CITY OF ALBUQUERQUE

**Re: Garcia Residence – Lot 11 Black Farms
Grading and Drainage Plan with Engineer's Stamp Dated 11-17-14
(C13D027B)**

Amy L. D. Niese, P.E.
Senior Engineer, Hydrology
Planning Department

ENGINEER'S SEAL 	LOT 11 BLACK FARM ESTATES GRADING AND DRAINAGE PLAN	DRAWN BY WCWJ DATE 11-17-14 21420-LAYOUT-11-17-14
11/17/14	 Rio Grande Engineering 1606 CENTRAL AVENUE SE SUITE 201 ALBUQUERQUE, NM 87106 (505) 872-0999	SHEET # —
DAVID SOULE P.E. #14522		JOB # 21420

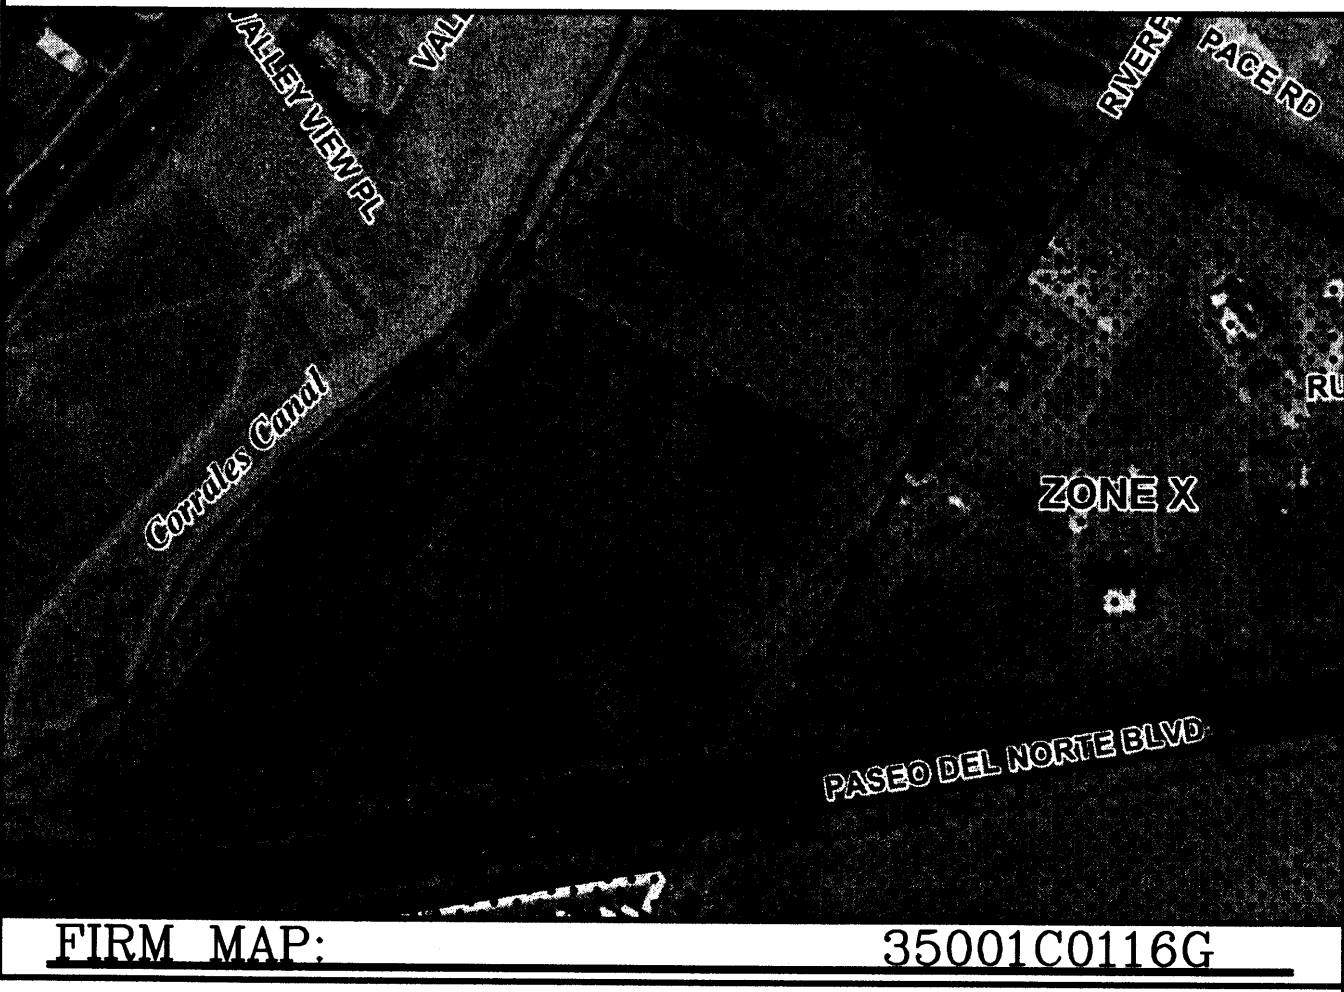
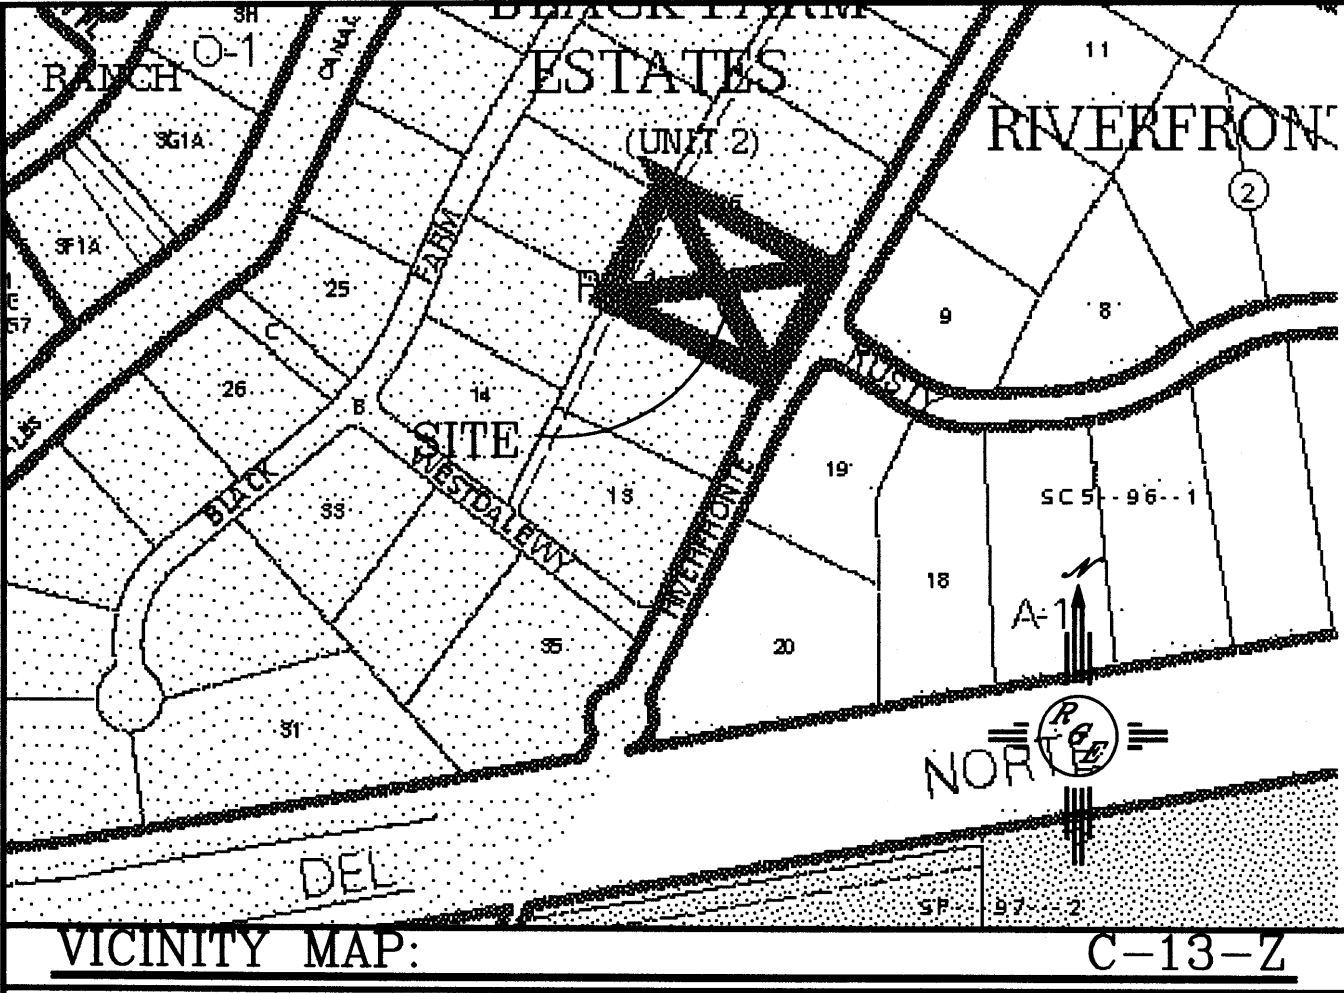
For future submittals, refer to water harvesting as First Flush. Calculate the First Flush as follows. Per the City Drainage ordinance, the 90th Percentile Storm Event, which is 44 inches, is to be managed. Reduce 0.44 inch by the 0.1 inch for the initial impervious abstraction in Table A-6 of Section 22 of the DPM. Multiply the remaining 0.34 inch by your impervious area. This is the amount of the First Flush necessary for the site.
